From: Amber Willard <Amber.Willard@arun.gov.uk>
Sent: 03 February 2020 09:17
To: Planning.Responses <Planning.Responses@arun.gov.uk>
Subject: FW: Objection to AW/337/19/A

From: Maureen Lord [REDACTED]
Sent: 29 January 2020 18:22
To: Amber Willard <Amber.Willard@arun.gov.uk>
Subject: Objection to AW/337/19/A

We wish to object to the planning application AW/337/19/A.

PROPOSED SITE SIGNAGE

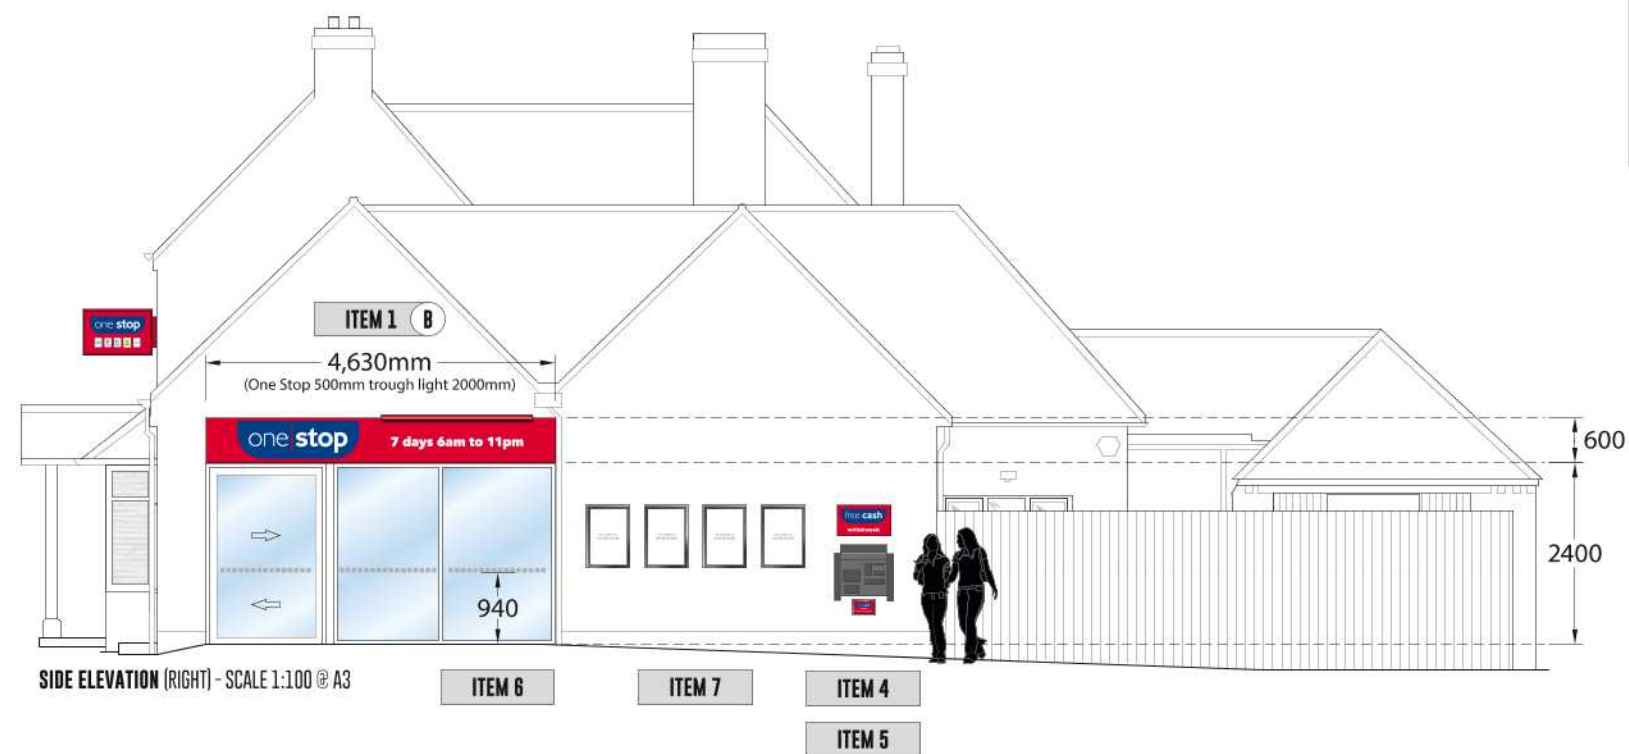
The signage that is proposed is very garish and totally out of keeping with this historic building and the surrounding residential area.

We understand that the car park will be flood lit at night .We live not far from The Ship and to have constant lighting on during the night will be an invasion of our privacy, changing a quiet,gentle and peaceful area into an alien environment .
